REPORT UPDATE

Application No: BN/10/15/HH

Recommendation Report for Planning Permission for Works or Extension to a Dwelling

PROPOSAL: Single storey extension to front elevation to provide enlarged entrance hall & utility room, loft conversion with 2no. pitched roof dormers

PROPOSED SECOND FLOOR PLAN

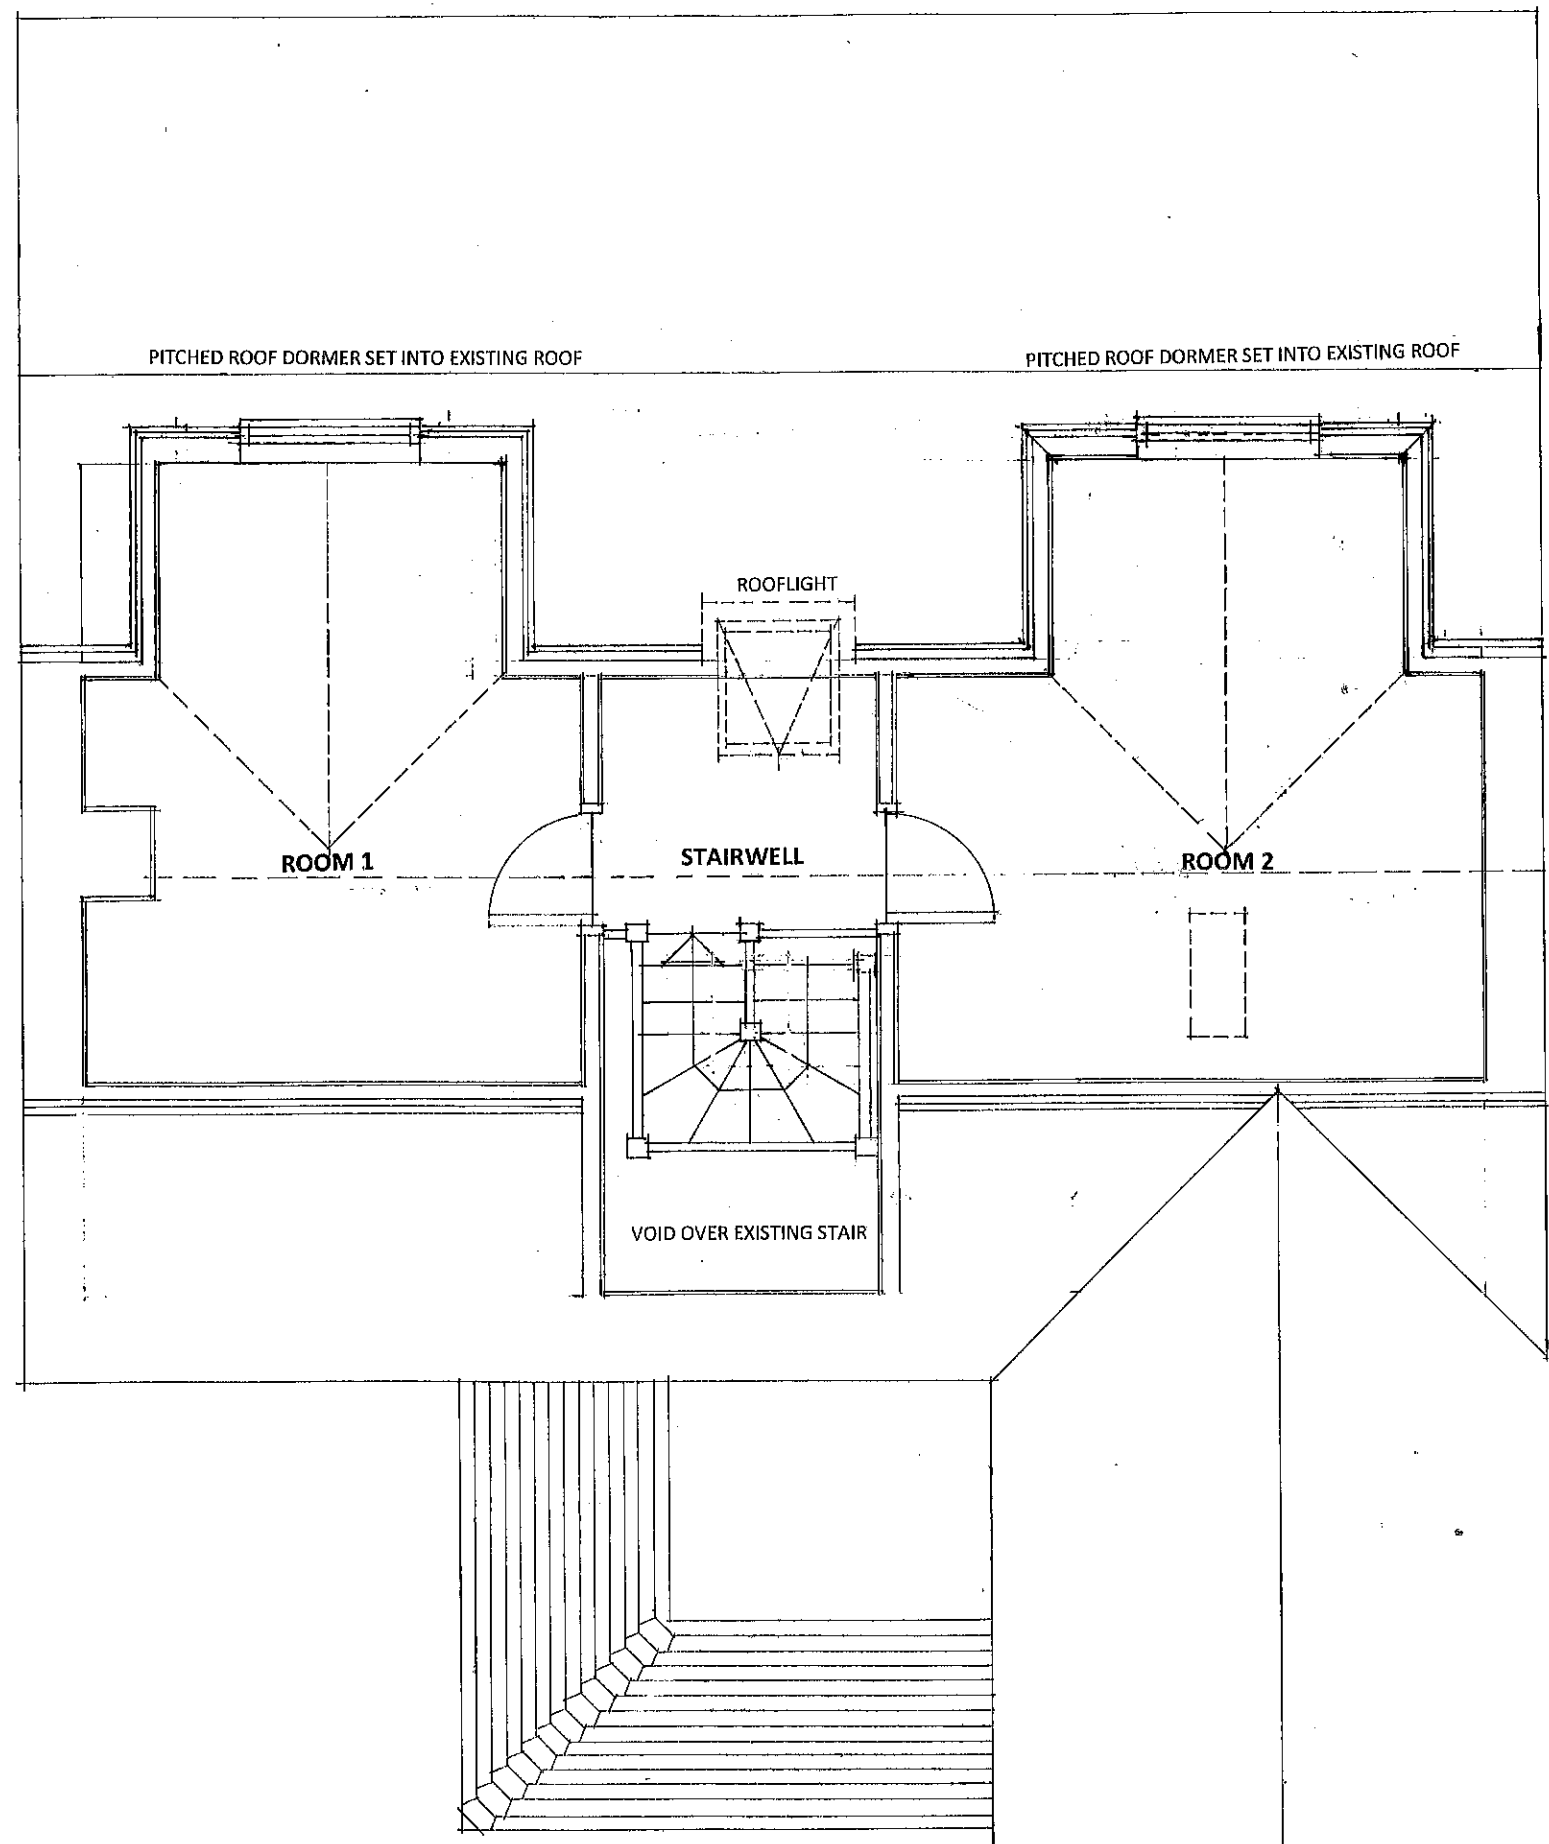
The proposed rear dormer windows could be carried out under permitted development without the need for permission. However, it is not considered that the windows in the dormers would increase the level of communal overlooking to neighbouring gardens to a damaging level.

NORTHWEST ELEVATION TO LAKE LANE

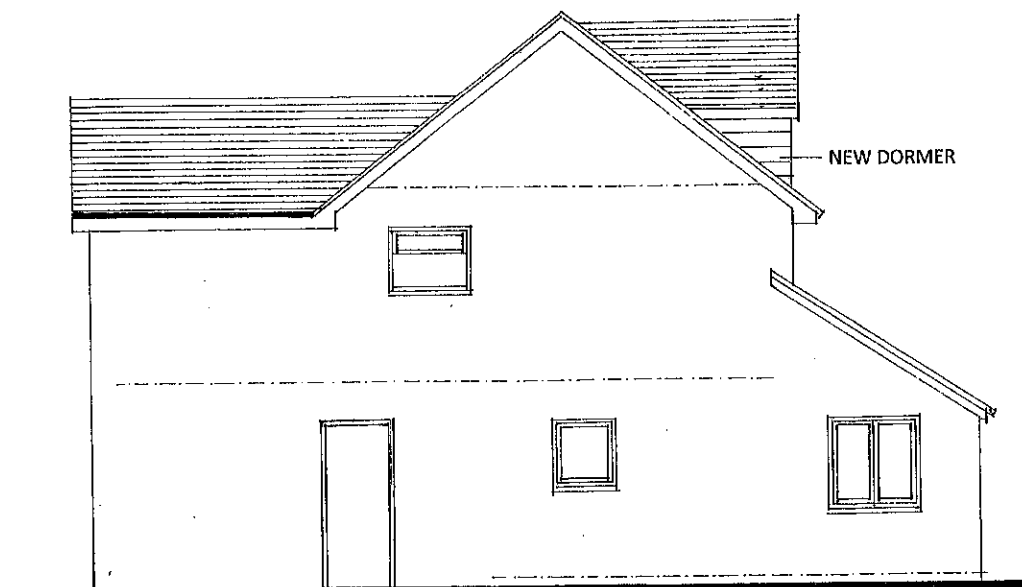
The proposed front porch would site between the front elevation and the side elevation of the two storey element. It would have a pitched roof and be constructed of materials to match. Given it would be modest in size it is considered to be subservient to the main dwelling and would not harm the appearance of the street scene.

SOUTHEAST ELEVATION TO GARDEN

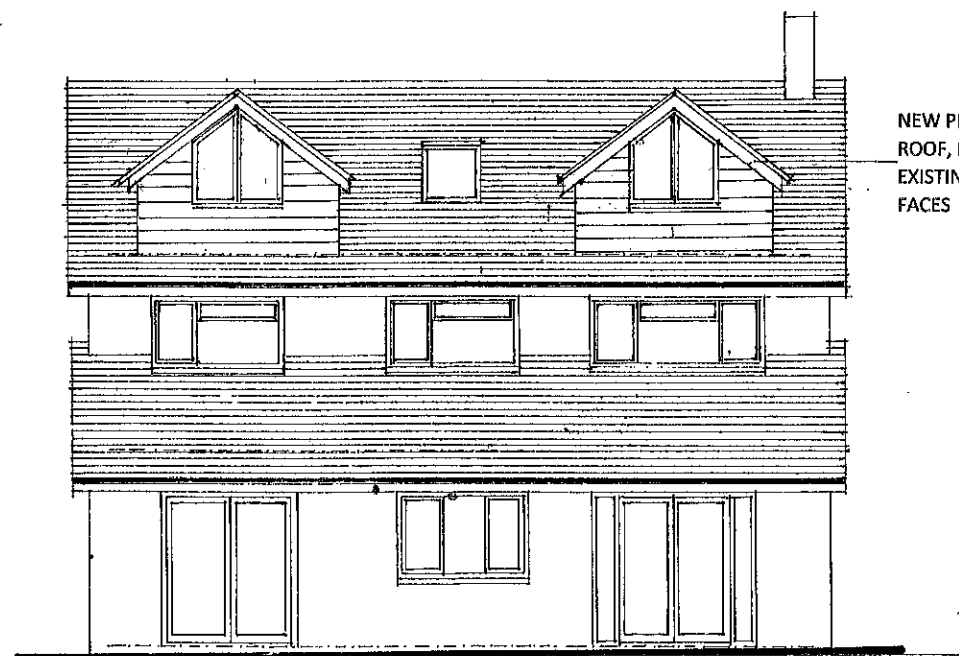
The Parish objects to the application in respect of the proposed dormer windows which as well as causing privacy issues for adjoining properties in Halliford Drive contravene the Neighbourhood Plan policy ES6: Contribution to local character. The rest of the proposed application details are acceptable.

The dormer windows could be carried out under permitted development without the need for permission. However, it is not considered that the windows in the dormers would increase the level of communal overlooking to neighbouring gardens to an unsatisfactory level. The Parish Council have objected due to conflict with policy ES6 of the Neighbourhood Plan. This policy states that new development should contribute to the character of the two villages. However the explanation for the policy states "The integration of new buildings into the context in which they are located is important." This suggests that the policy is intended to address wholly new buildings rather than extensions to existing buildings.

property, it is not considered that their visual impact would be damaging to the character and appearance of the street scene. In terms of their impact on the dwelling from the rear as they are modest in size and do not dominate the roof slope they are considered to be respectful to the character of the property and subservient to its character.
